DEPARTMENT OF PLANNING AND DEVELOPMENT

July 17, 2003

RE: 57 Melbourne St. (015 F016)

An evaluation of the exterior rear decks and stairway at the above location on 7/14/03 revealed that the structure fails to comply with the Building Code (1999 BOCA) of the City of Portland. Attached is a list of the violations and copies of the referenced Code sections. The structure was erected pursuant to Building Permit # 01-1486. The following is a list of deficiencies:

PROPOSED ADDITION PLAN

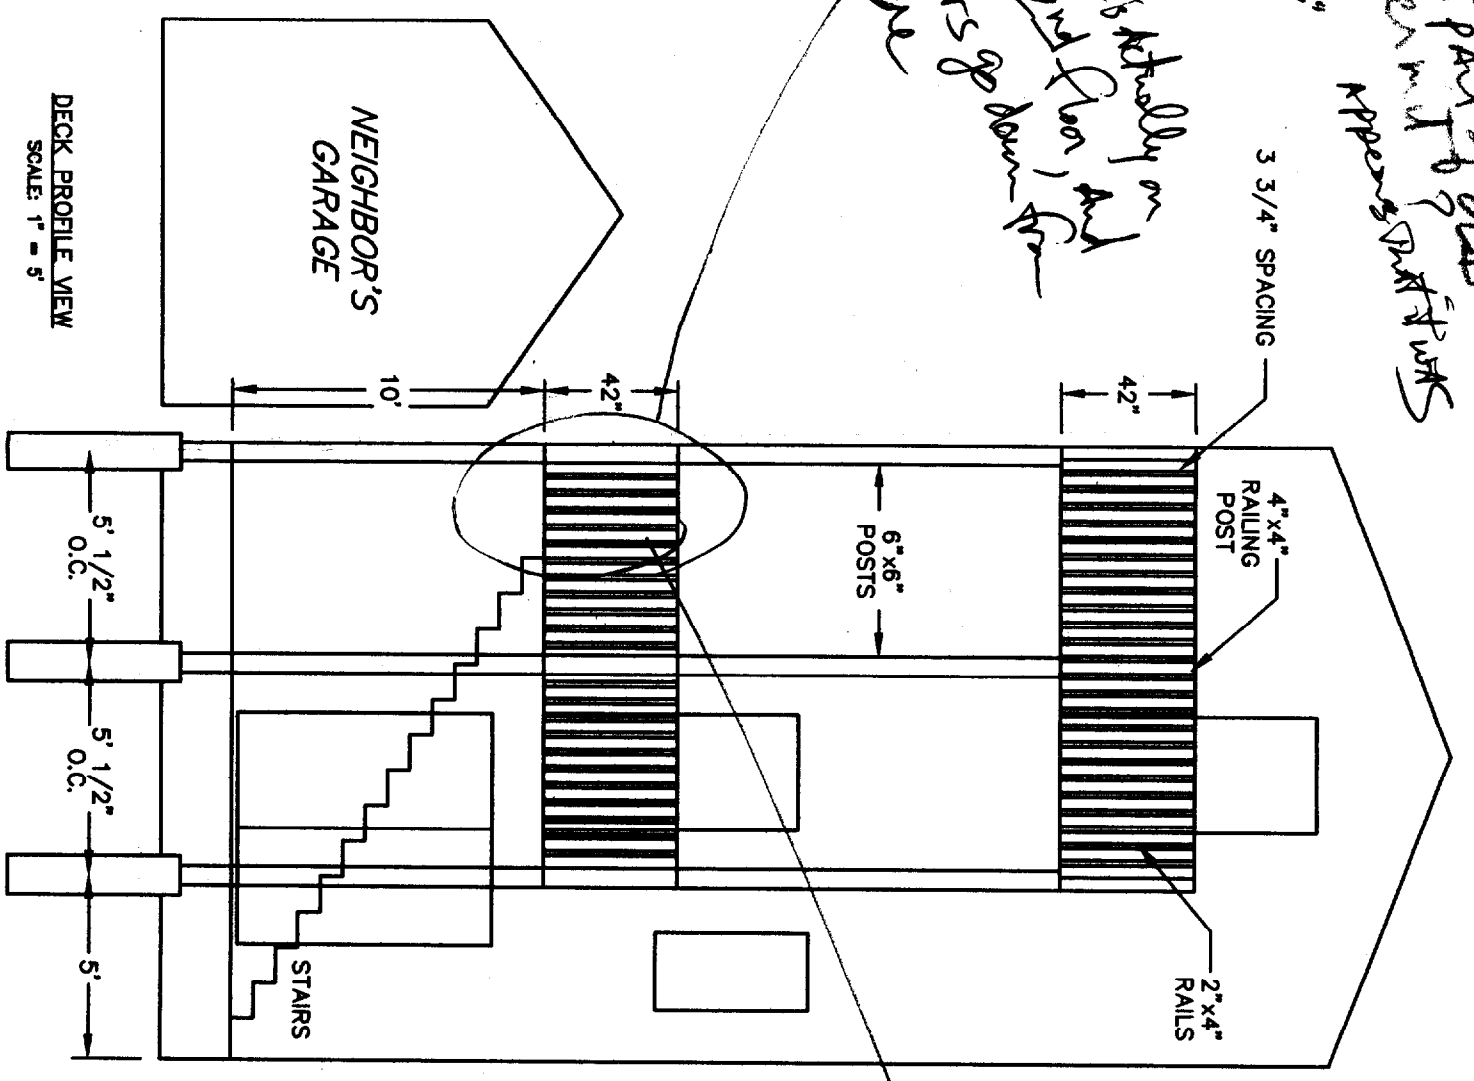
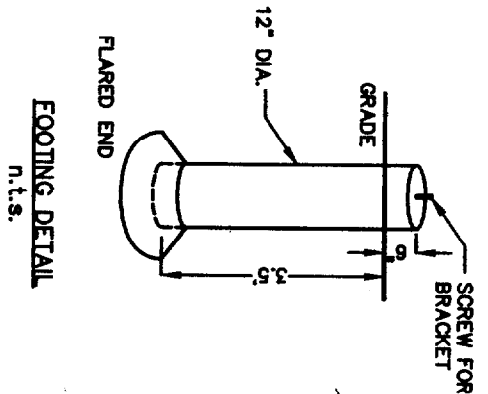
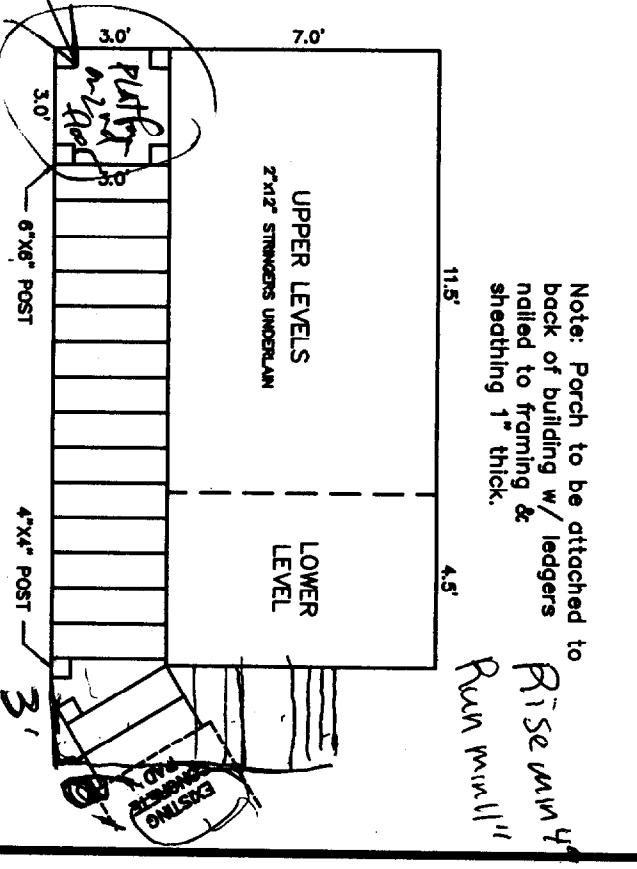
- 1) The Stairway was constructed differently than the approved plan; in violation of Section 111.3 of the Building Code.
- 2) The 9" Treads and 8" Risers fail to comply with the 11" Tread and 7" Riser standard; in violation of Section 1014.6 of the Building Code.

- 3) There is no guard on the right side and the left side is 34" in height instead of the required 42"; in violation of Section 1014.7 & 1005.5 of the Building Code.

- 4) There are no balusters on the stair guard that was present and the stair risers are open; in violation of Section 1021.3 of the Building Code.
- 5) The triangle openings that are formed by the tread, riser and guardrail exceeds 6"; in violation of Section 1021.3.1 of the Building Code.

- 6) There is no graspable handrail; in violation of Section 11022.2.4 of the Building Code.
- 7) The landing is outside of the footprint of the original structure and requires further review from the zoning administrator.

- 8) The permit requires amendment to include the changes specified in item #7

All work must cease, and new plans reflecting code compliant changes must be submitted for a permit amendment by 7/25/03. The correction must occur by 8/15/03. A reinspection of the premises will occur on 8/18/03 at which time compliance will be required.
